From: Matthew Eason <mj4.matt@gmail.com>
Sent: 20 May 2021 23:34
To: Iqraa Malik
Subject: Re: FG/89/21/HH Revised plans
Attachments: We sent you safe versions of your files; 25 Ocean Drive - Proposed Elevations REV 5.pdf; 25 Ocean Drive - Proposed Roof and Plan View REV 5.pdf

Unfortunately, this application is still invalid for the following reasons:

Ref - FG/89/21/HH - 25 Ocean Drive

Ground Floor Layout

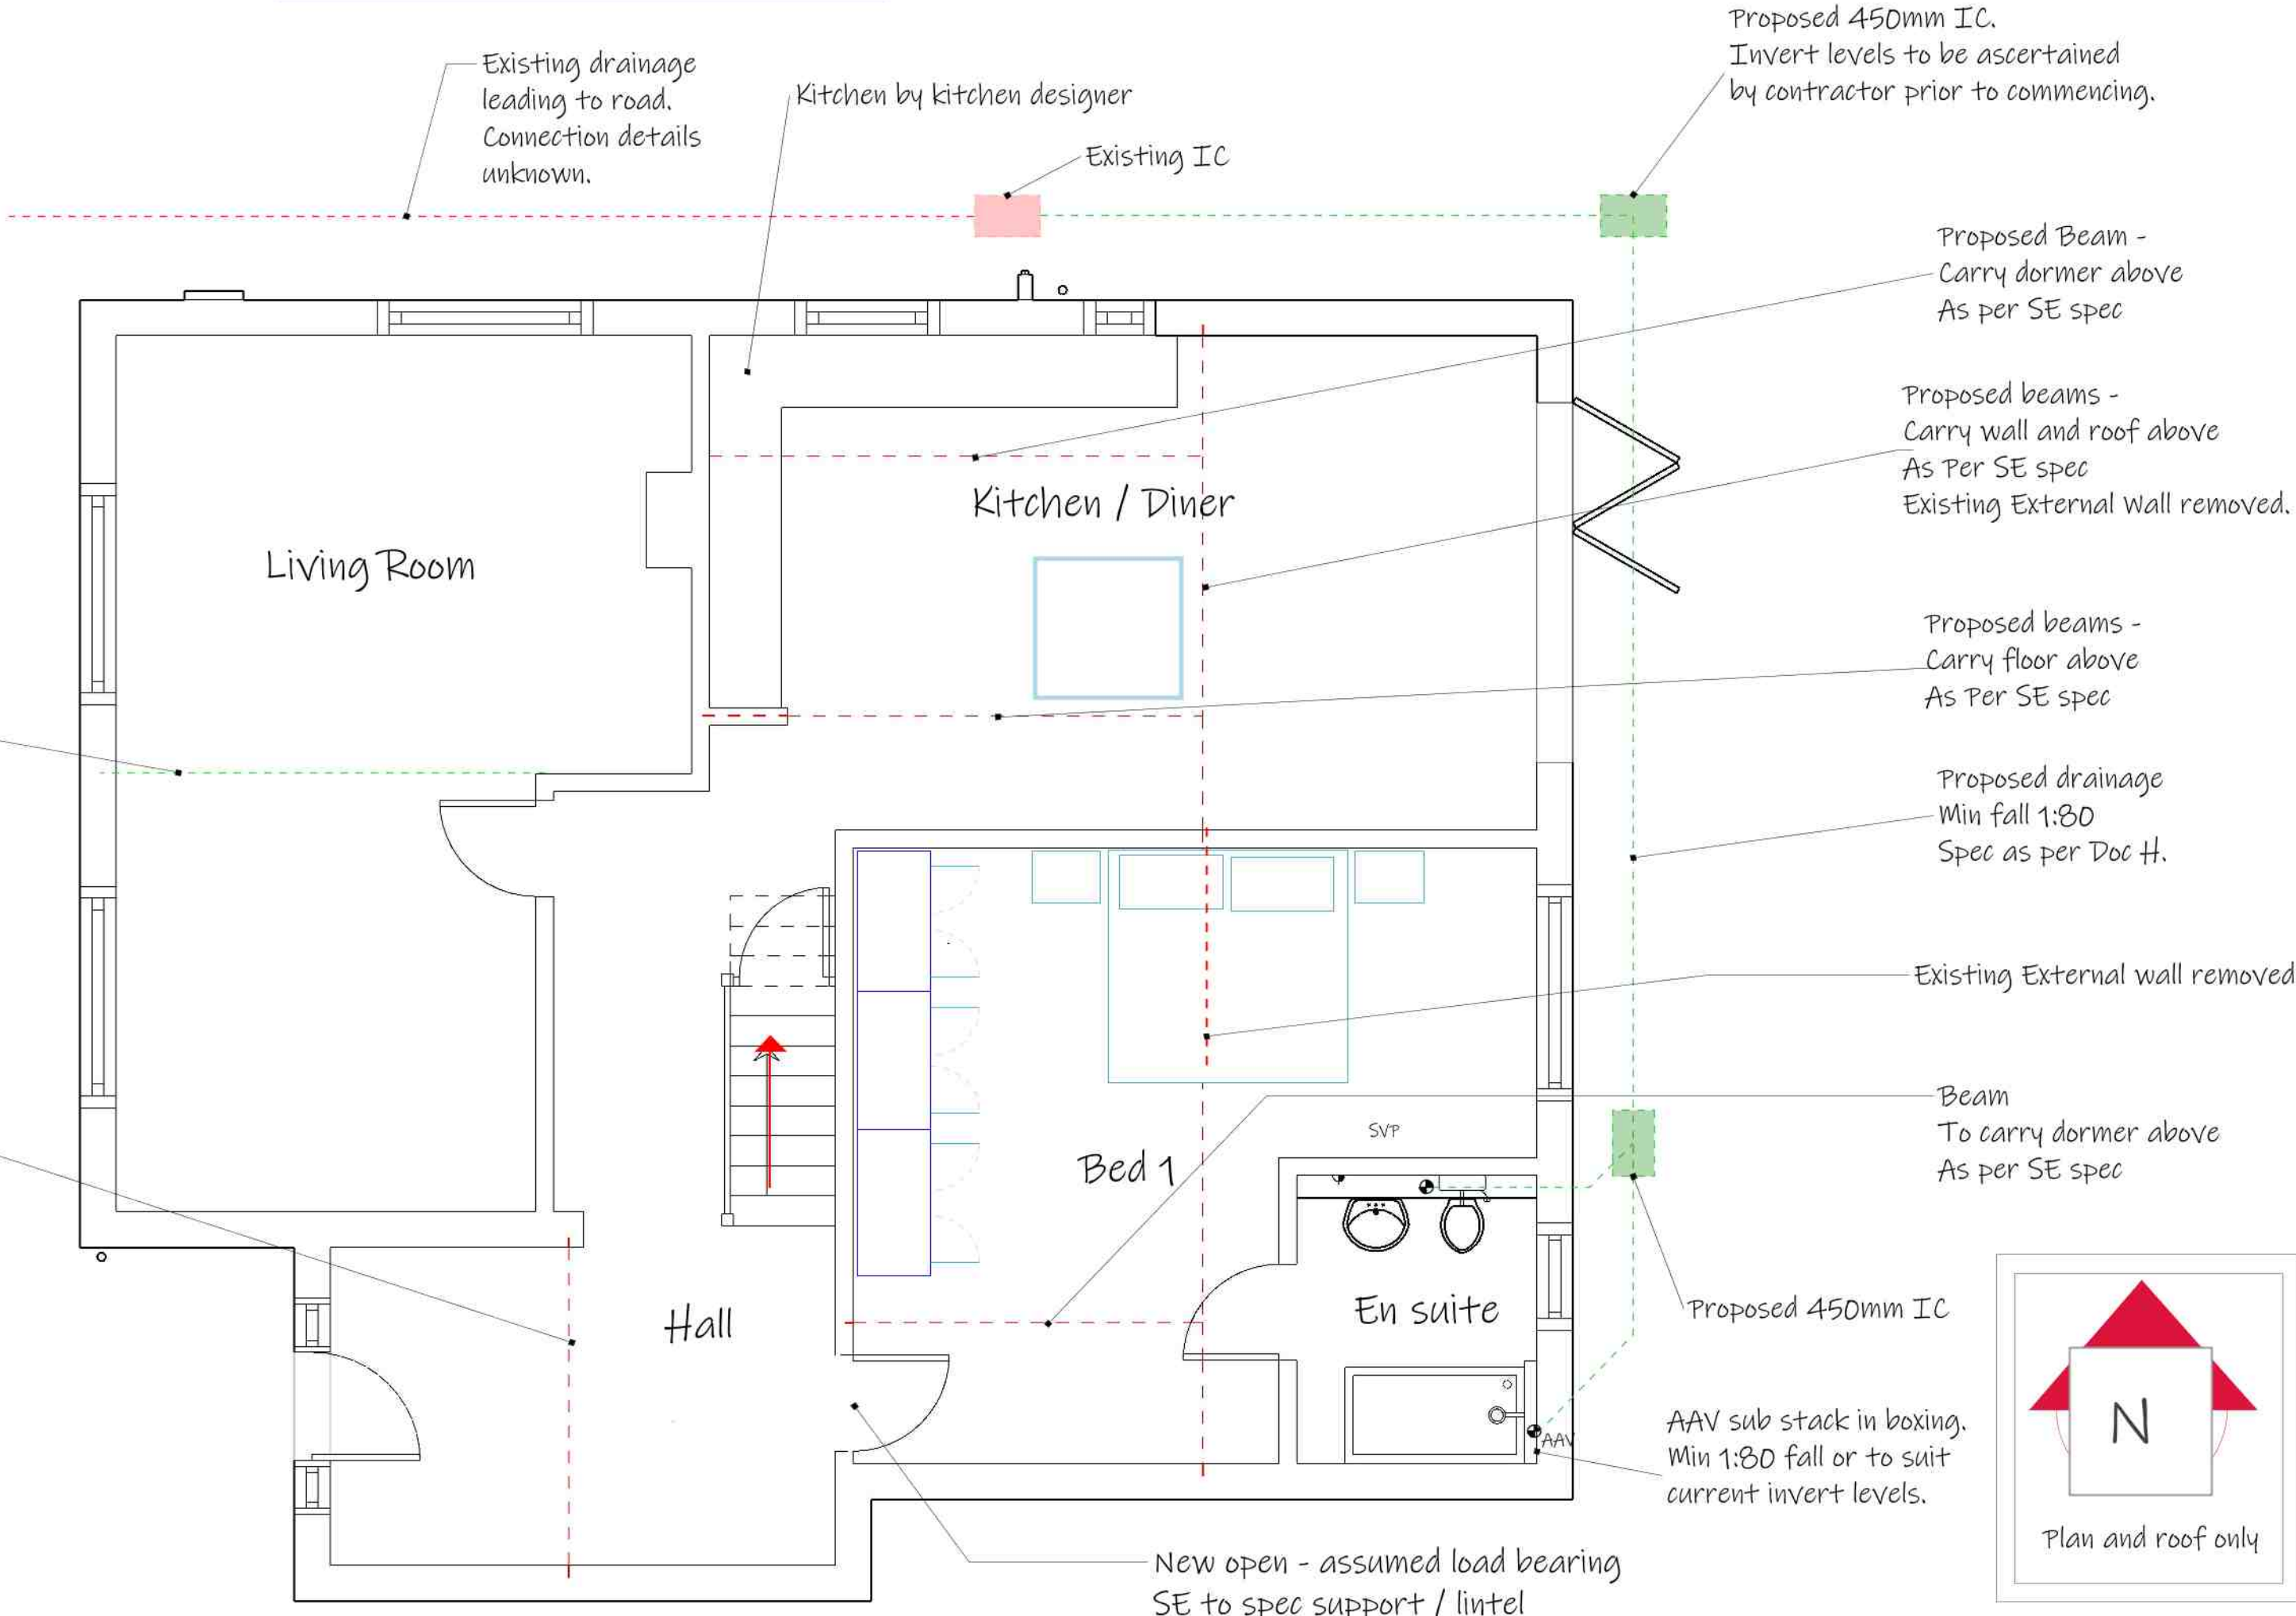
Proposed Plans: The rear window shown on the proposed first floor is missing from the proposed rear elevation

Proposed Plans: The ground floor window placement is inconsistent between the proposed ground floor plan and the north elevation.

The above mentioned window has been removed from the 1st floor plan.
